CITY OF ALBUQUERQUE  
PLANNING DEPARTMENT  
February 4, 2009  
DRB Comments

PROJECT # <sup>100-7646/</sup>1004677 APPLICATION # 09-70033

RE: Tract 131, MRGCD Map # 38

A.C.S. MONUMENT
 "14-J13"
 NORTHING = 1480158.086
 EASTING = 1514405.083
 G-G 0.998884887
 CC = 0074°31.93"
 NAVD 1983

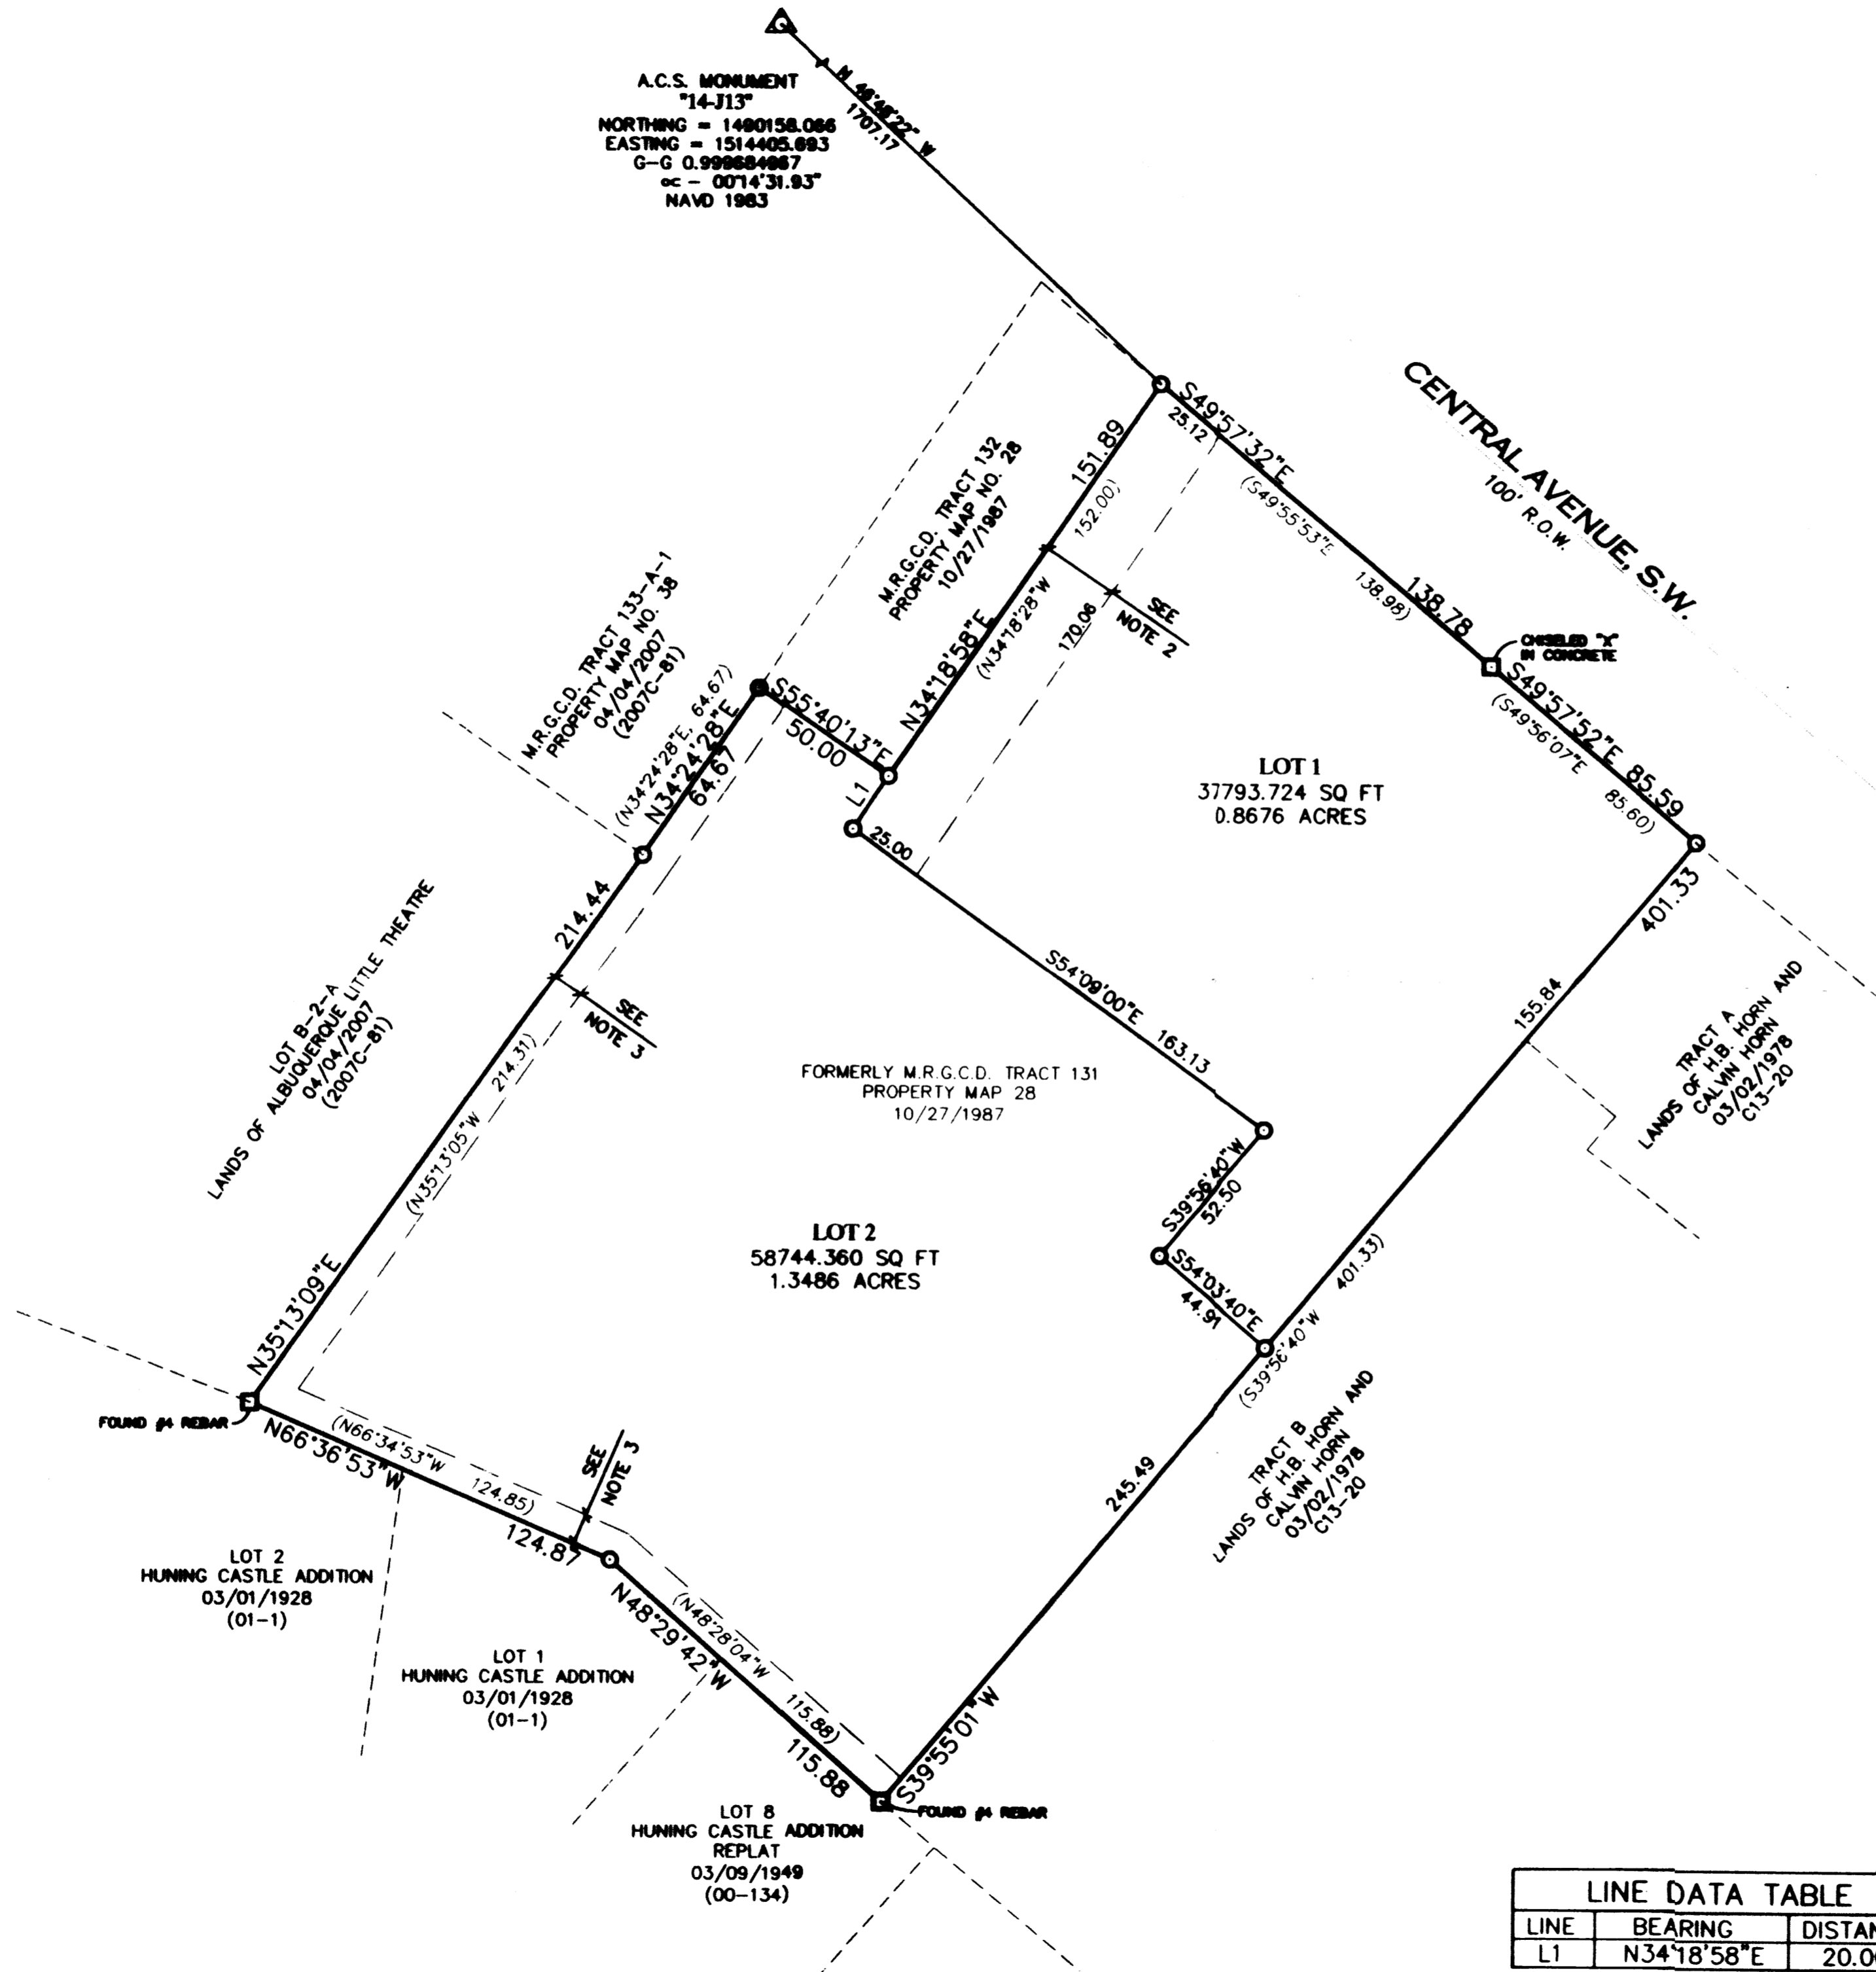
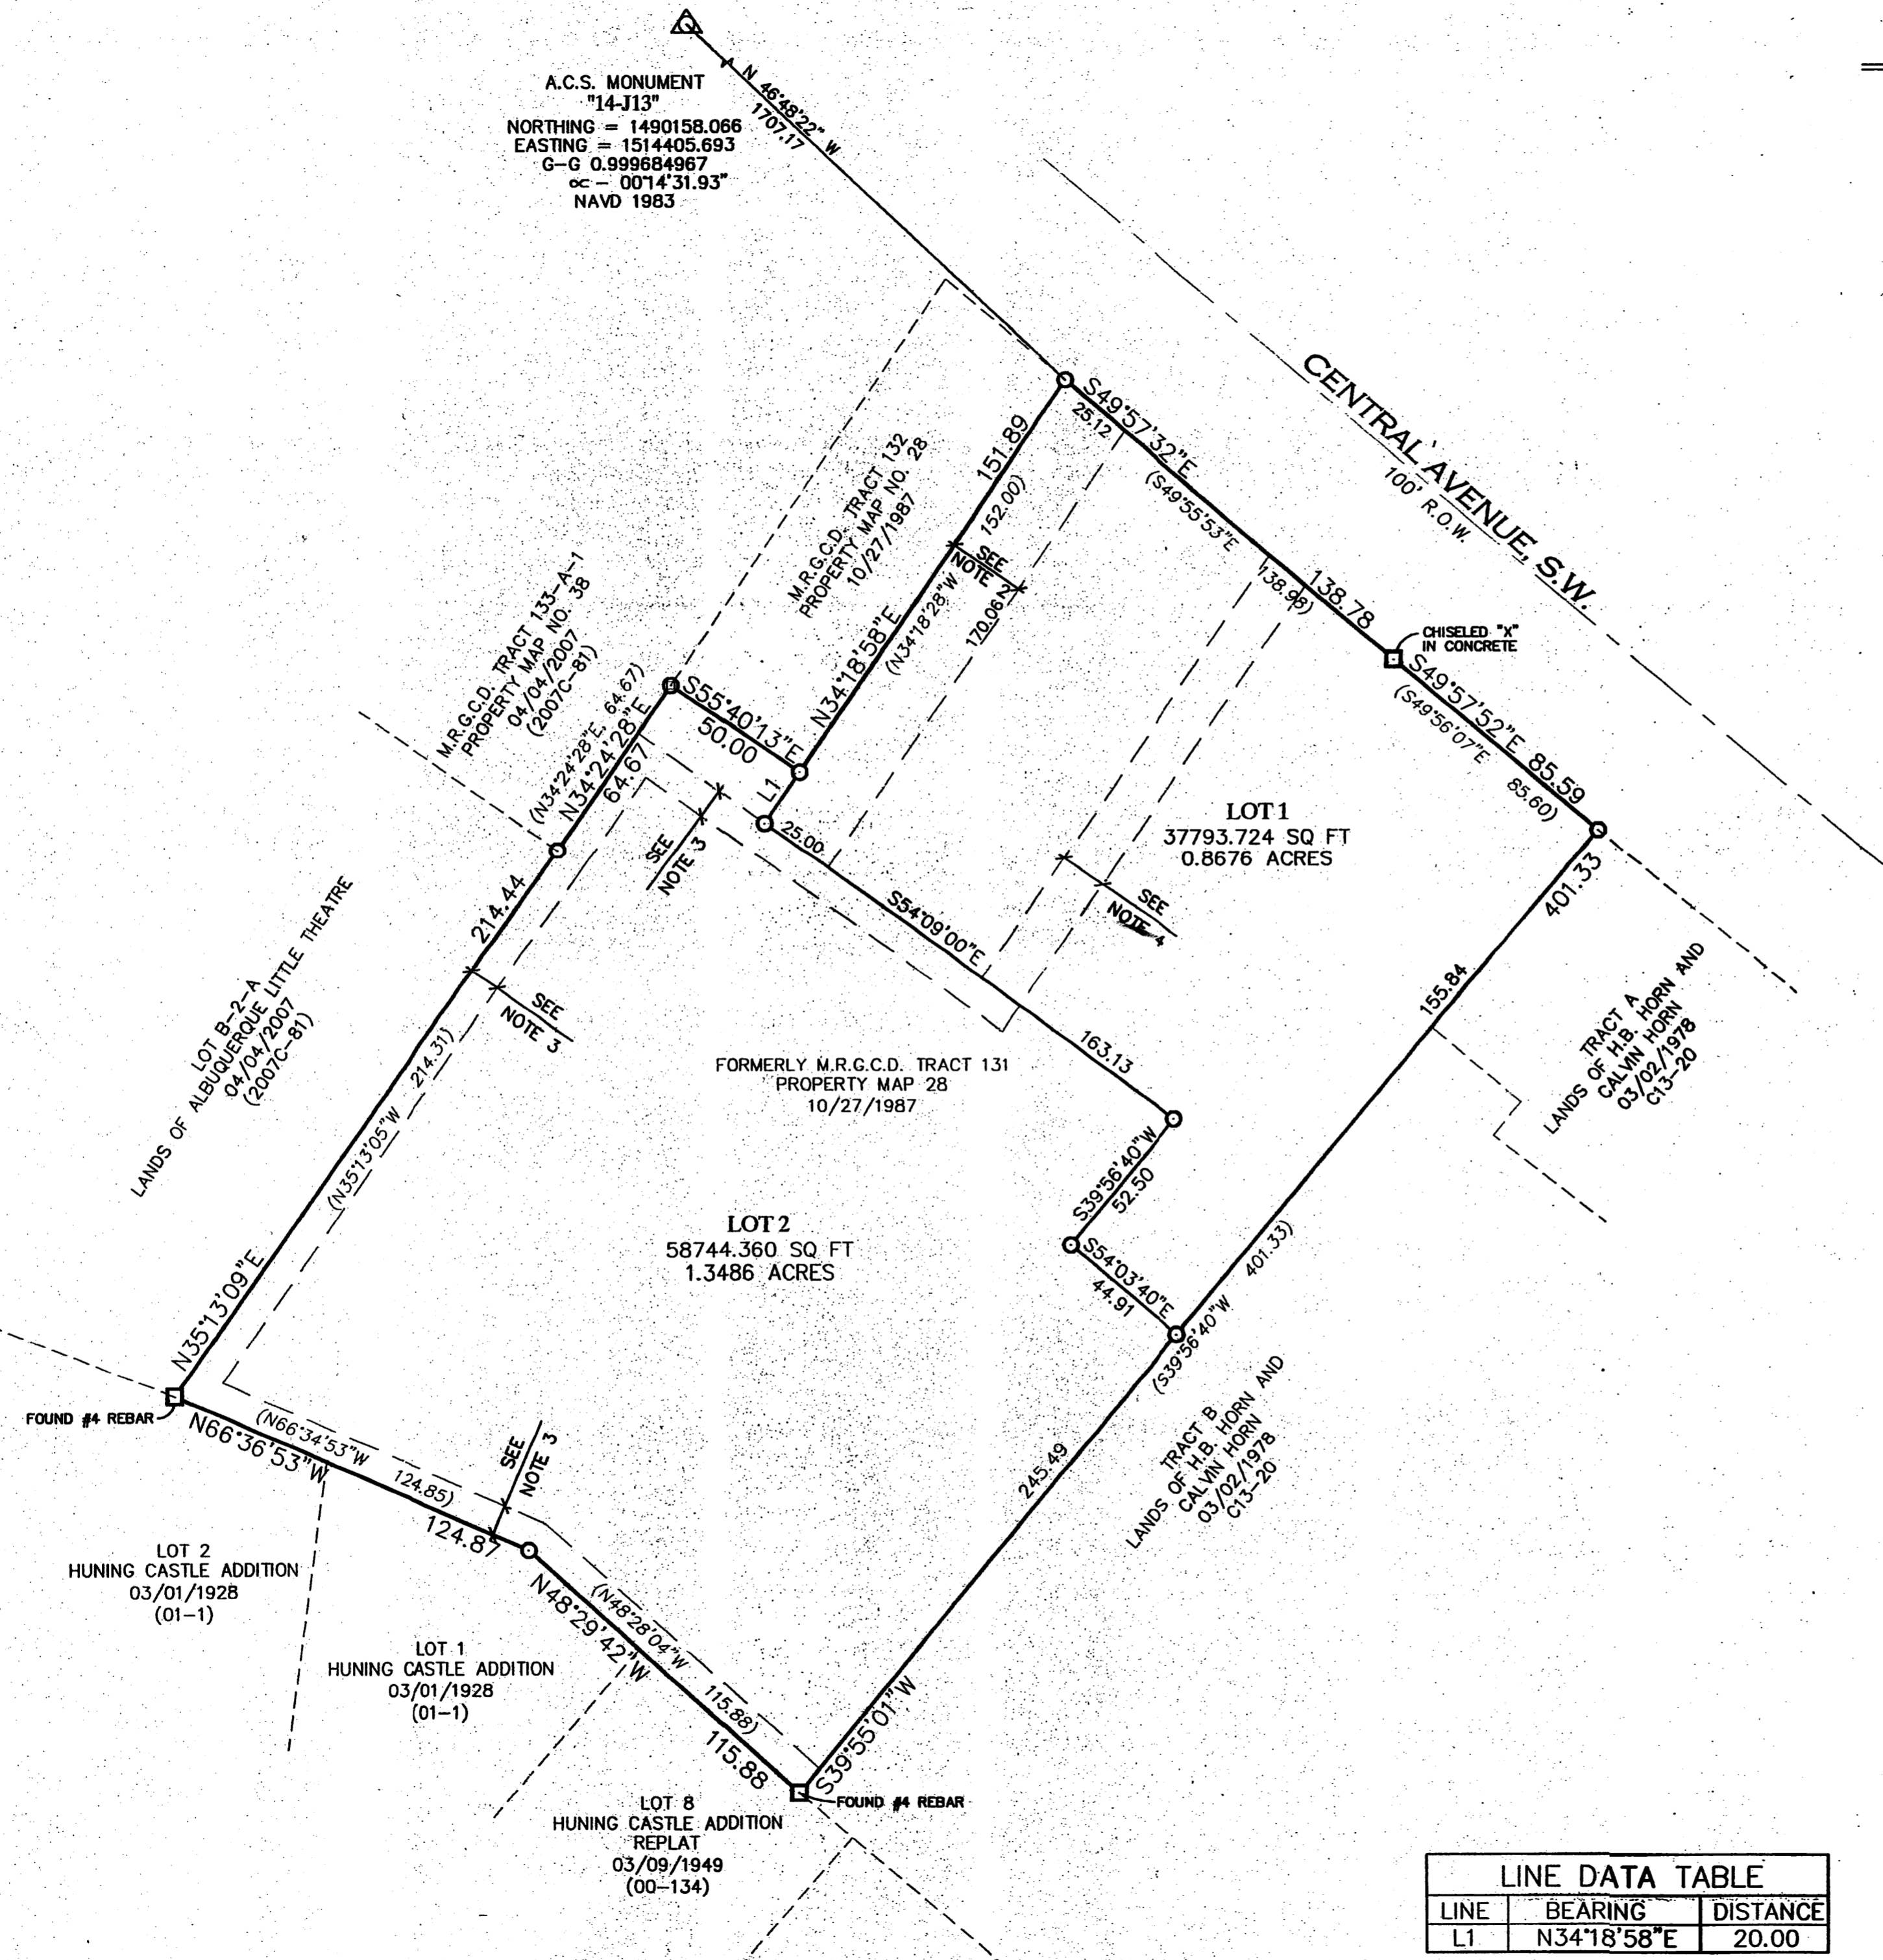
It appears Tract 132 needs to be a beneficiary of the proposed cross-lot easement.

A site plan with parking calculations is needed to demonstrate that required on-site parking per the Zoning Code is met on-site (on each lot). If proposed lot line goes through the existing apartments, an engineer or architect will have to certify that the property line wall complies with the Building Code, or the building would need to be removed prior to filing of the plat.

Please remove zoning note (I.) from Final Plat. For future reference, please revise Solar Note to be specific to this type of request, i.e. use the words "THIS PLAT" (rather than the words "REQUESTED FINAL ACTION") at the beginning of the note, and do not use the words "OR SITE DEVELOPMENT PLAN FOR SUBDIVISION" at the end of the note.
